**Application by Vattenfall Wind Power Limited for the Thanet Extension Offshore Wind Farm Development
Consent Order**

The Examining Authority's second written questions and requests for information (ExQ2)

Crown Land Plan  
(Offshore)

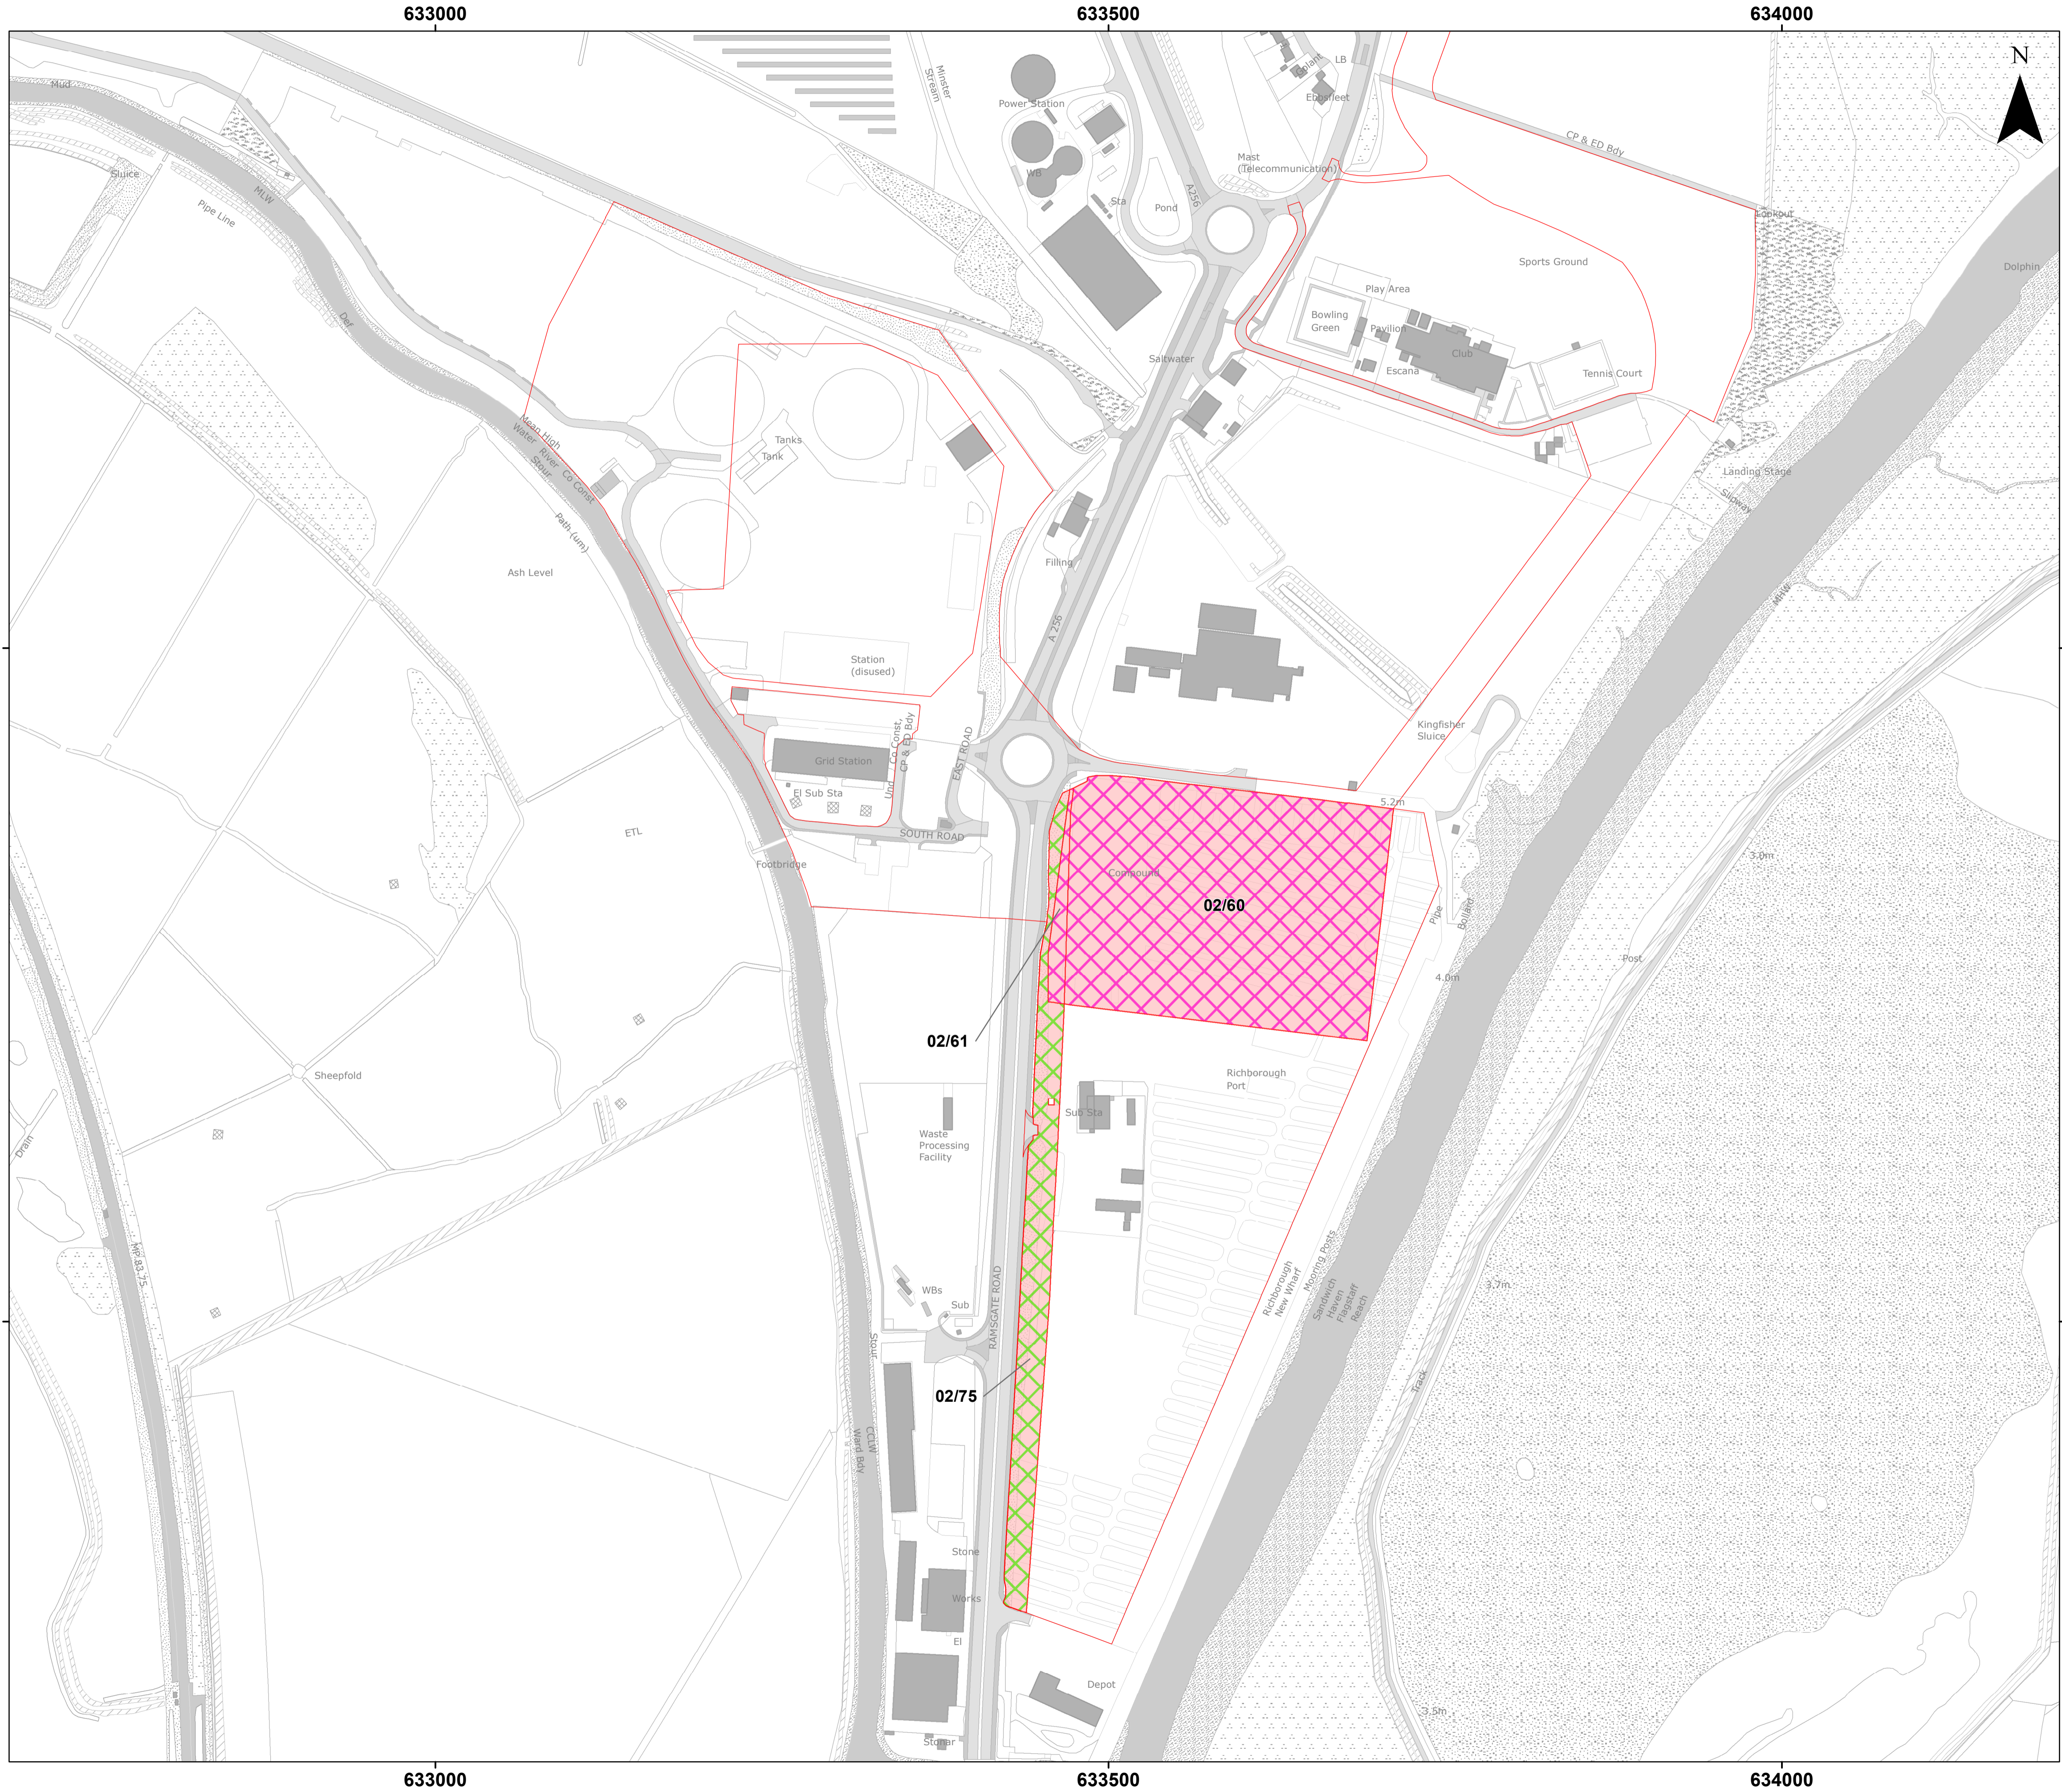
ExQ2	Question:	Response:
2.3	Compulsory Acquisition, Temporary Possession and other Land or Rights Considerations	
2.3.1.	<p>Crown Lease: Effect on CA Case At CAH1 [EV-039], the Crown Estate made oral submissions in summary that there was not yet an agreement to grant a lease to the Applicant for the offshore elements of the proposed development and that the potential to extend the Thanet Offshore Wind Farm was presently subject to a plan-level HRA which would not be complete until after the closure of this Examination and related to a potential lease area for a maximum installed capacity of 300 MWe.</p> <p>a) In circumstances where a lease for the offshore elements has not been committed to, can any estimate be made of the likelihood of a lease being granted?</p> <p>b) If a lease was unlikely to be granted (49% probability or less) or was not granted, would that have any implications for the Applicant's CA case for land required onshore for grid connection works?</p> <p>c) Are there any circumstances in which the plan-level HRA could reasonably conclude that an extension to the existing Thanet Offshore Wind Farm should not proceed and can any</p>	<p>a) While The Crown Estate and the Applicant may not have entered into an agreement for lease for the Thanet Extension Offshore wind farm development by the closure of the Examination on 11 June 2019, the parties are working to be able to, subject to the outcome of the plan level Habitats Regulations Assessment, exchange such an agreement as soon as possible thereafter.</p> <p>b) That would be a matter for the Examining Authority and the Applicant.</p> <p>c) It is not appropriate to pre-judge the outcome of the ongoing plan level HRA process.</p> <p>d) It is not appropriate to pre-judge the outcome of the ongoing plan level HRA process. In any event, the Applicant's case for CA in relation to onshore matters should be assessed by the Examining Authority independently from the outcome of The Crown Estate's plan level HRA.</p> <p>e) The Crown Estate would grant the Applicant an agreement for lease for a maximum installed capacity of 300 MW or such other maximum capacity as is agreed between the parties. Subject to the Applicant first having obtained all necessary consents for the construction and operation of the wind farm a lease would be</p>

2.3.2.	<p>Crown Lease: Effect on CA Case Paragraph 2.6.46 – 2.6.48 of NPS EN-3 recognises that in awarding an agreement for</p>	<p>The Crown Estate is not aware of any such constraining conditions.</p>

ExQ2	Question:	Response:
	<p>lease for an offshore wind extension project, leases may be subject to “<i>various constraining conditions, including the presence of an existing operational wind farm</i>”. Can the Applicant and the Crown Estate please identify whether there are any constraining conditions that may be applicable in this case?</p>

**Crown Land Plan  
 (Onshore)**

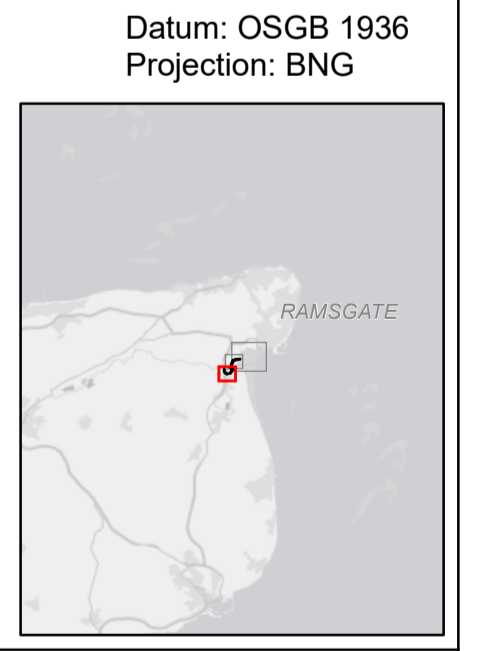
2.3.4.	<p>Crown Consent: PA2008 s135 PA2008 s135(2) provides that ‘[a]n order granting development consent may include any other provision applying in relation to Crown land, or rights benefiting the Crown, only if the appropriate Crown authority consents to the inclusion of the provision’. At CAH1 [EV-039], the Crown Estate made oral submissions in summary that as there was no onshore Crown Land subject to CA or TP, there was no need for the Crown to provide consent. There have been two NSIP examinations and Secretary of State decisions that have considered the question of Crown consent in the absence of any onshore Crown Land: Triton Knoll Array and Burbo Bank Extension Offshore Wind Farms. Both ExA recommendations and SoS decisions were clear that the failure to identify solely offshore Crown interests in sea-bed in a Book of Reference was</p>	<p>a) The Crown Estate and the Applicant are working together to enable The Crown Estate to provide the necessary consent under PA2008 s135(2) prior to determination of the Applicant’s application.</p> <p>b) Any PA2008 s135 consent relating to the Border Force lease area in the Ramac land is a matter for the Ministry of Justice and not The Crown Estate.</p>

ExQ2	Question:	Response:
	<p>b) Turning to onshore development, the Border Force lease area in the Ramac land is understood to be held by the Ministry of Justice (MoJ). An effect of the CA of this site is that the Border Force compound would be relocated. The Crown Estate and the applicant are asked:</p> <ul style="list-style-type: none">i. Whether this lease is a 'right benefitting the Crown' for the purposes of PA2008 s135(2) and hence whether consent is required before the Order can be made?ii. If consent is required, is the Crown Estate capable of granting that consent or must it be granted directly by or on behalf of the MoJ? If the latter, the applicant is requested to seek consent and to advise the ExA and submit a copy of the relevant correspondence once it is obtained.
